From: Laura Gibbons <Laura.Gibbons@arun.gov.uk>
Sent: 31 May 2019 13:34
To: Simon Davis <Simon.Davis@arun.gov.uk>
Subject: RE: Planning Consultation on BE/60/19/DOC 182 Chichester Road

Engineers Comments Regarding Condition 4- surface water drainage

© This drawing is the copyright of Robert Clark Associates Limited It may not be copied or reproduced without their written authority			
Scale As shown		At original A3	
Drawing Number 2024/SK2		Revision -

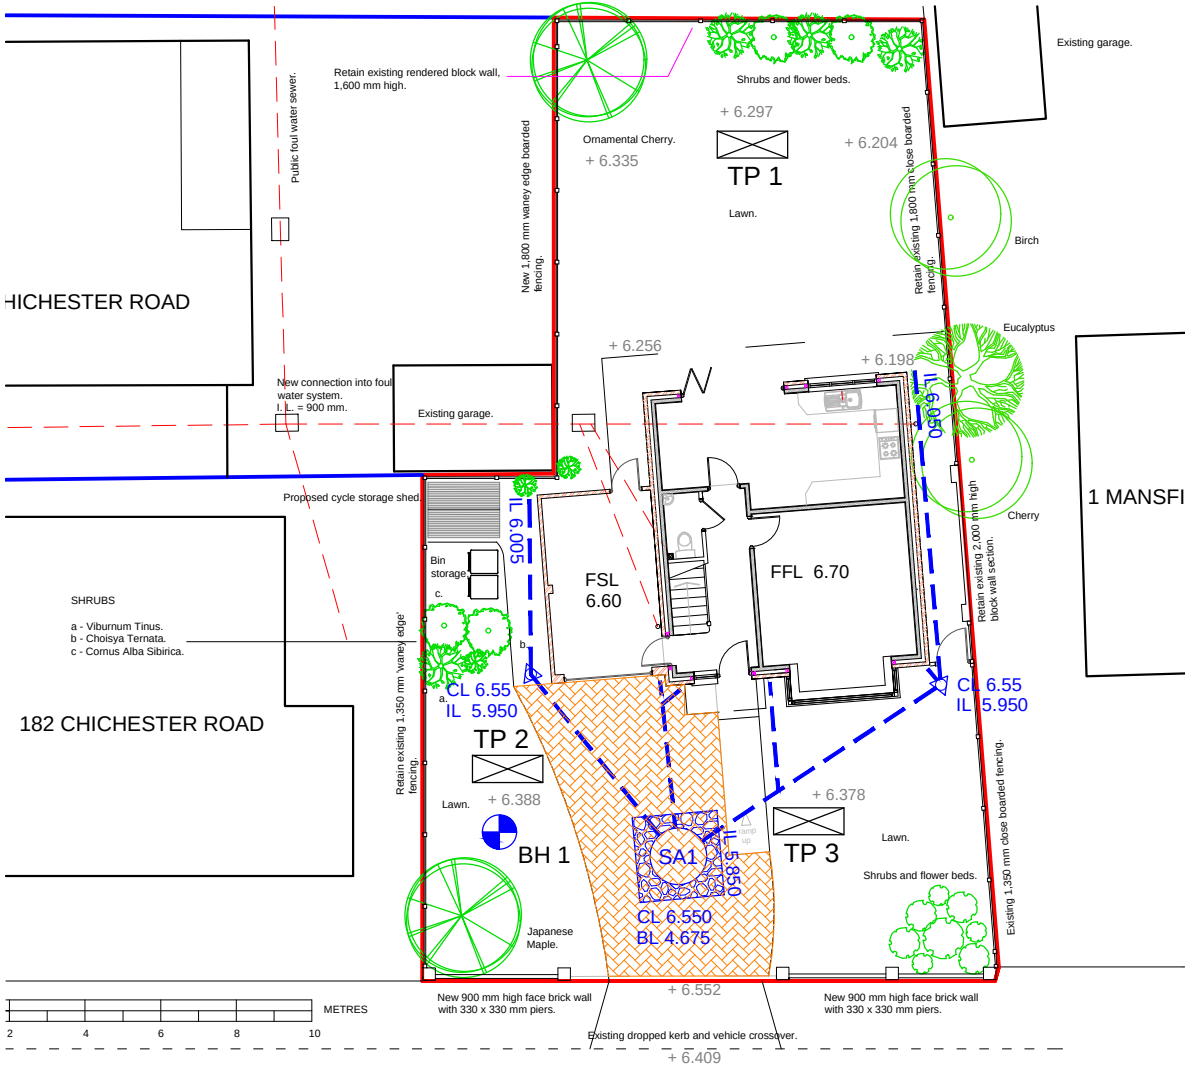
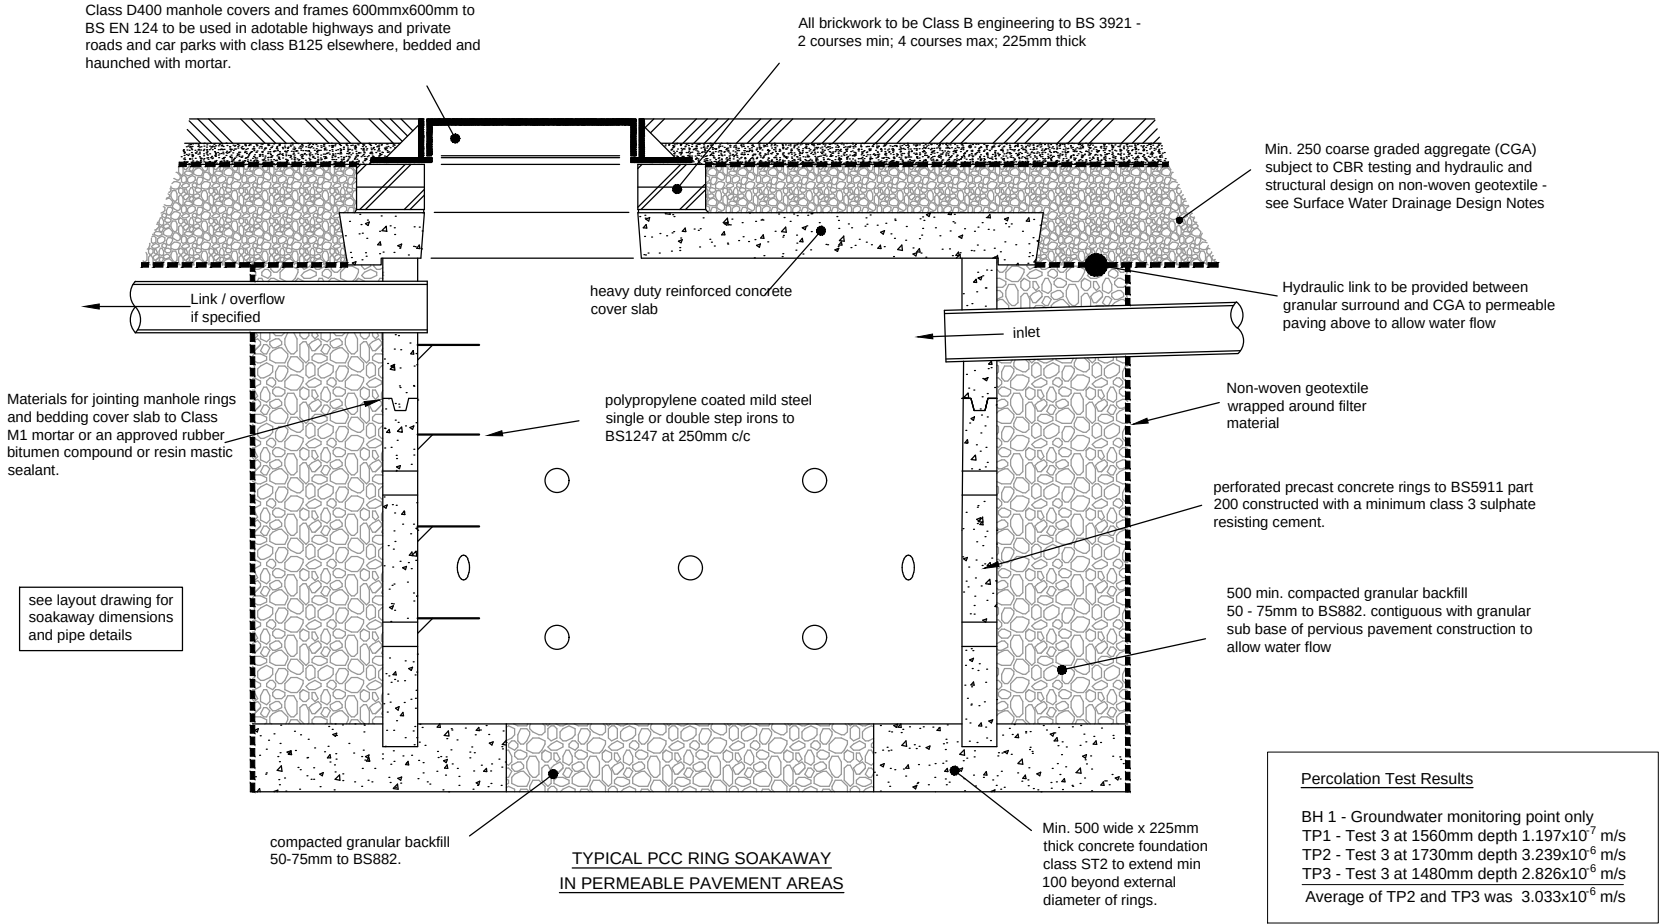
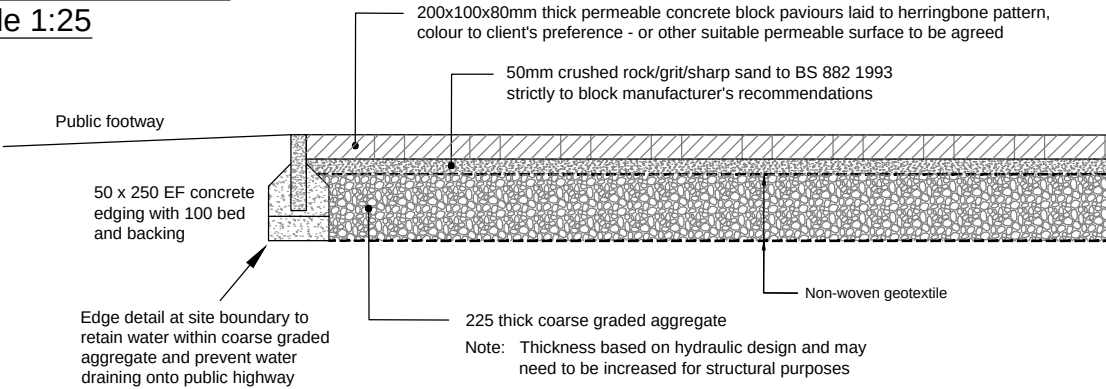
- No calculations have been submitted with the application. Please can these be provided.
- Average infiltration rates have been used in design. We require worst case results to be used. Please can further detail on the infiltration testing results be submitted, i.e. depths and locations of testing and results.
- It is unclear if winter groundwater monitoring has been completed. Please can the applicant confirm the duration of groundwater monitoring.

I attach a copy of the calculations to accompany the design submitted for the soakaways.

Scale As shown	At original A3
Drawing Number 2024/SK3	Revision -

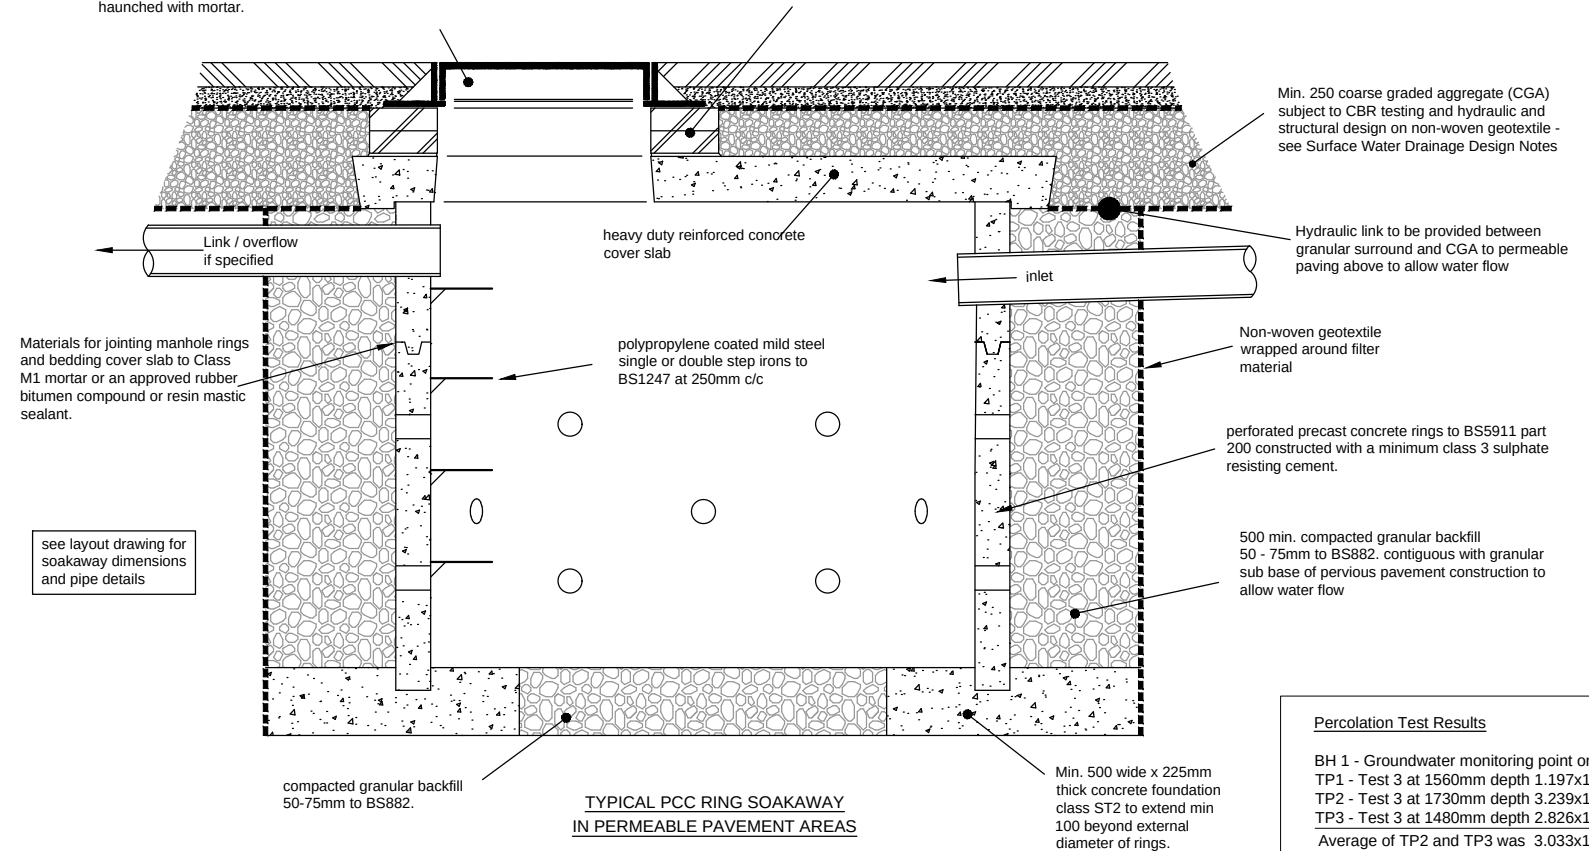
- Average infiltration rates have been used in design. We require worst case results to be used. Please can further detail on the infiltration testing results be submitted, i.e. depths and locations of testing and results.
- It is unclear if winter groundwater monitoring has been completed. Please can the applicant confirm the duration of groundwater monitoring.

I have revised the calcs as requested and it makes just 4mm difference in the subbase depth required from 214 to 218mm. I designed 225mm depth anyway, so there is no change to the design

Please see attached drawing and calcs for formal substitution.
